## Department of Transportation

October 1, 2019

RE: Trails at Aspen Ridge (Springs East at Waterview) - PUDSP-191 - From Revised TIS review and Drainage Submittals.

Figure 3

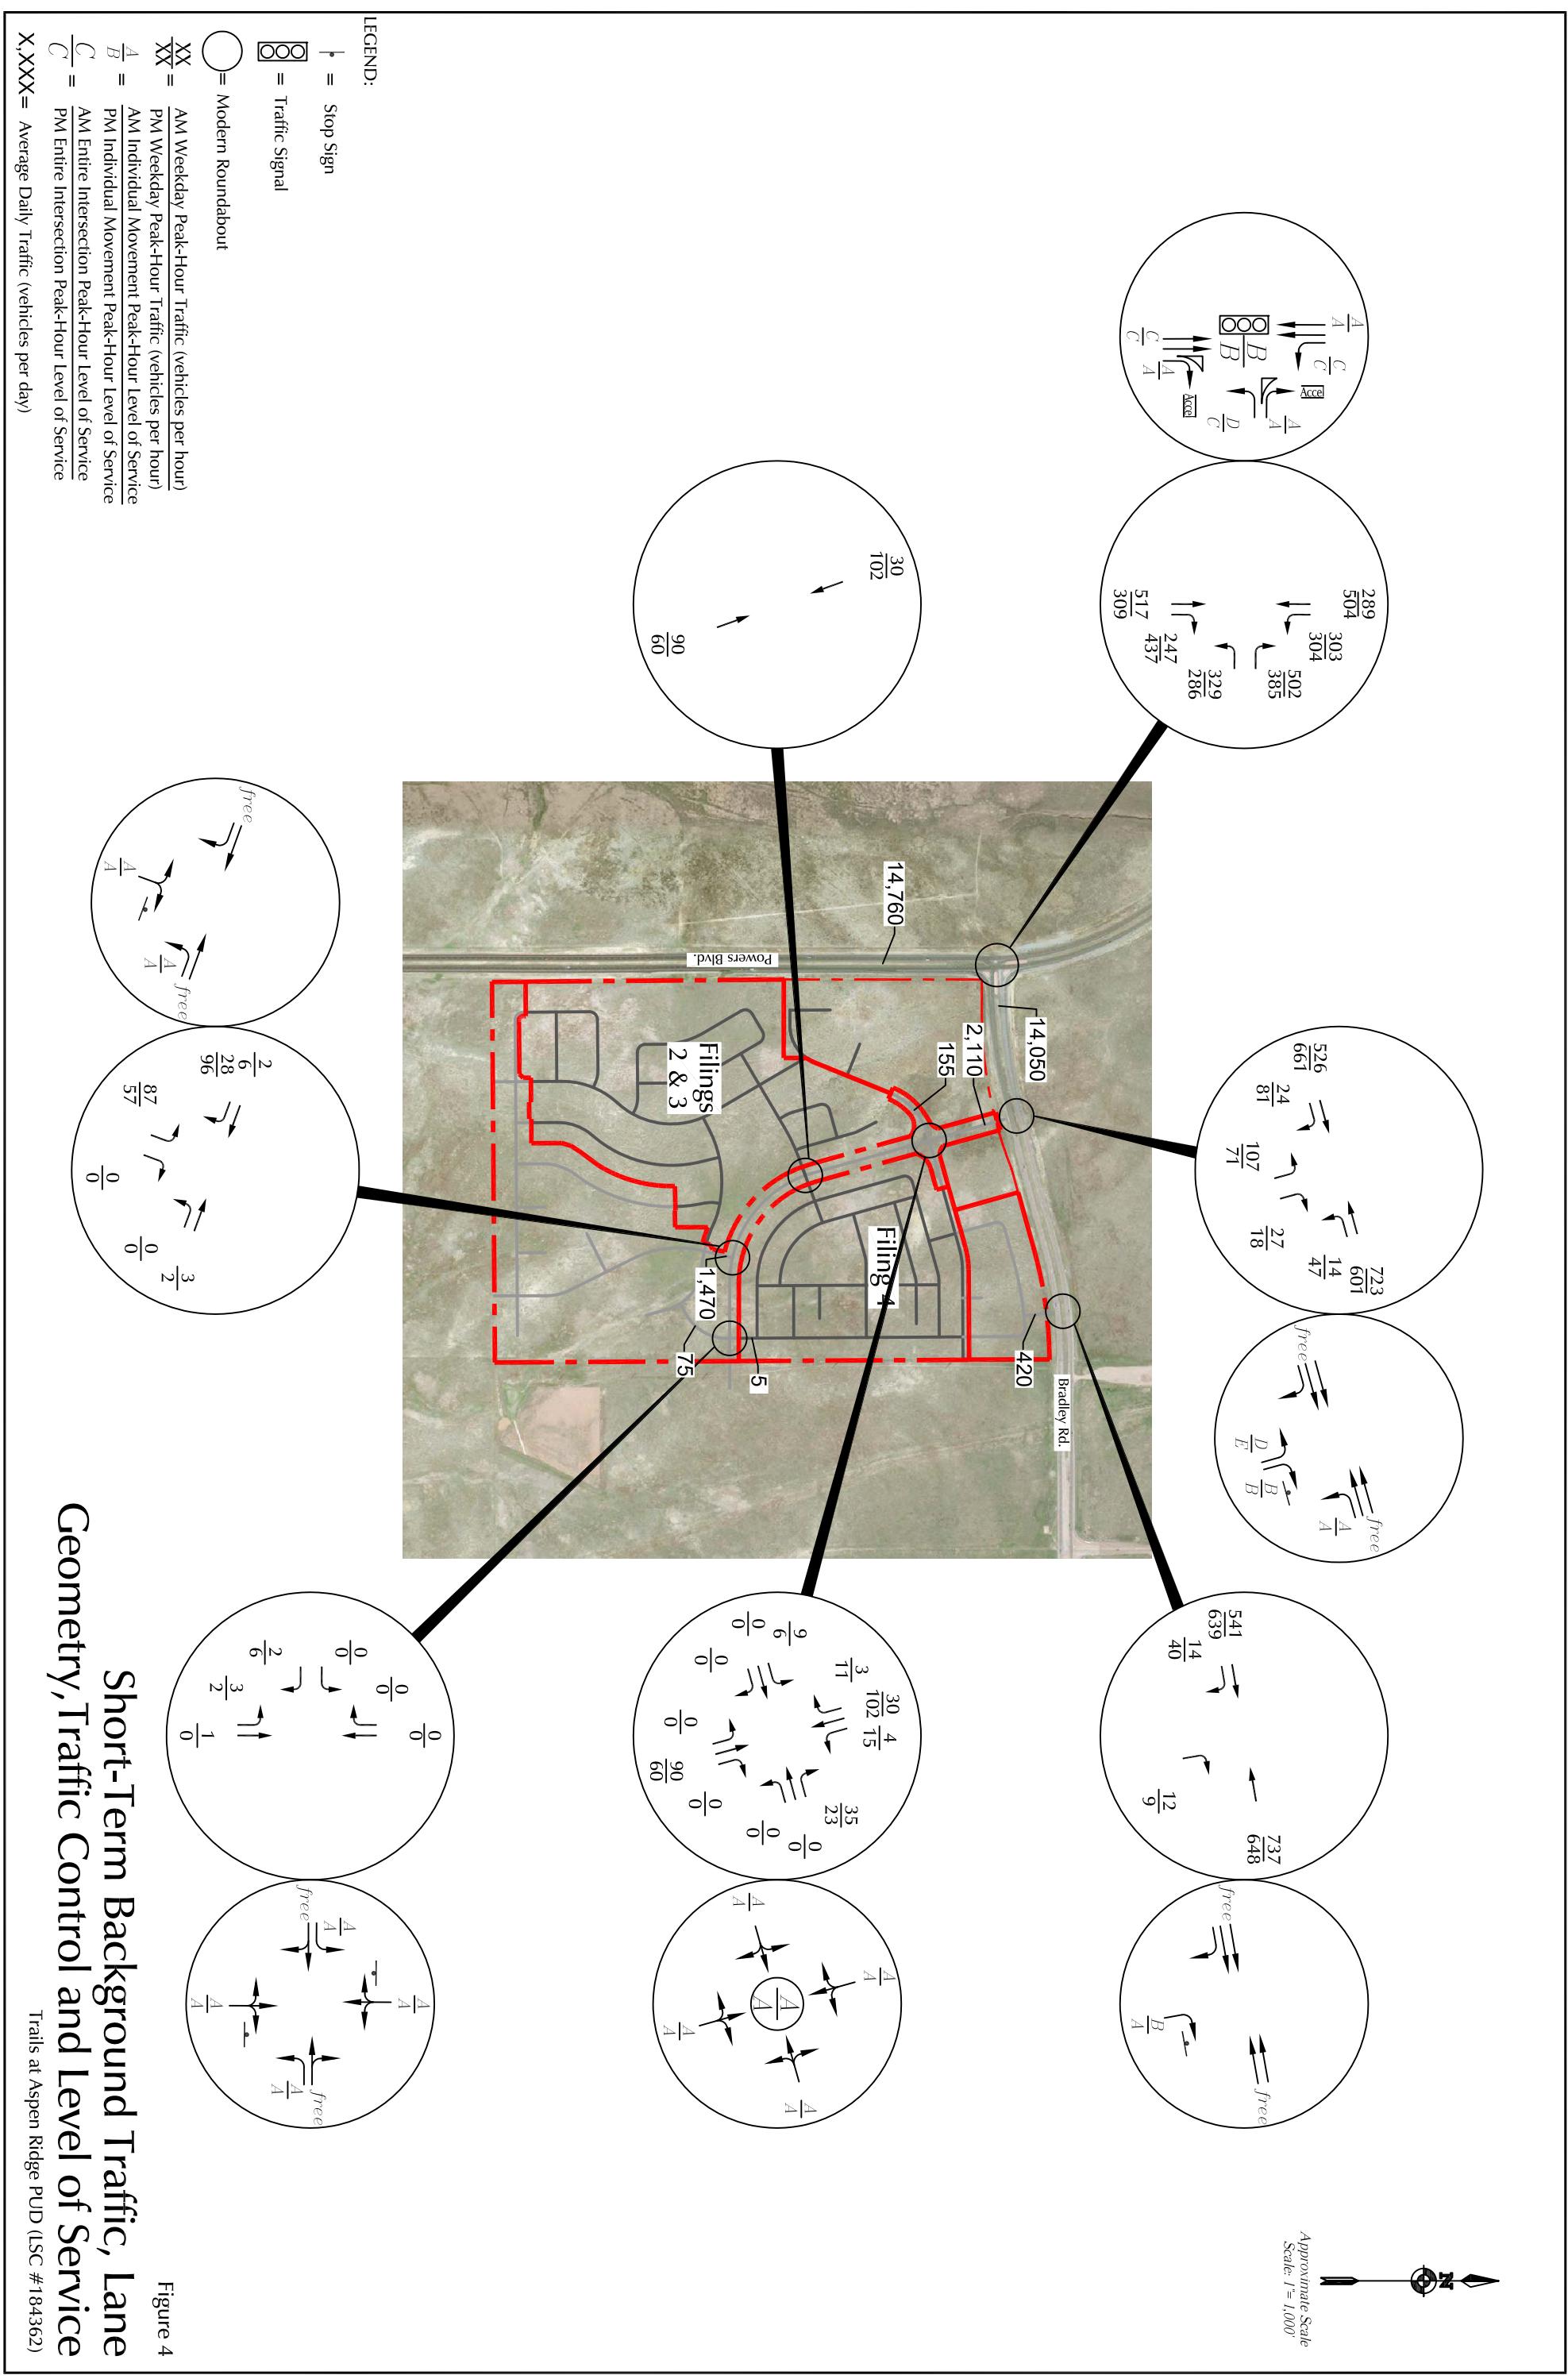
- e. The 2040 Syncro reports for Powers Blvd. Interchange Northbound Ramp at Bradley Rd is missing the existing left turn traffic in both time periods from Figure 13.
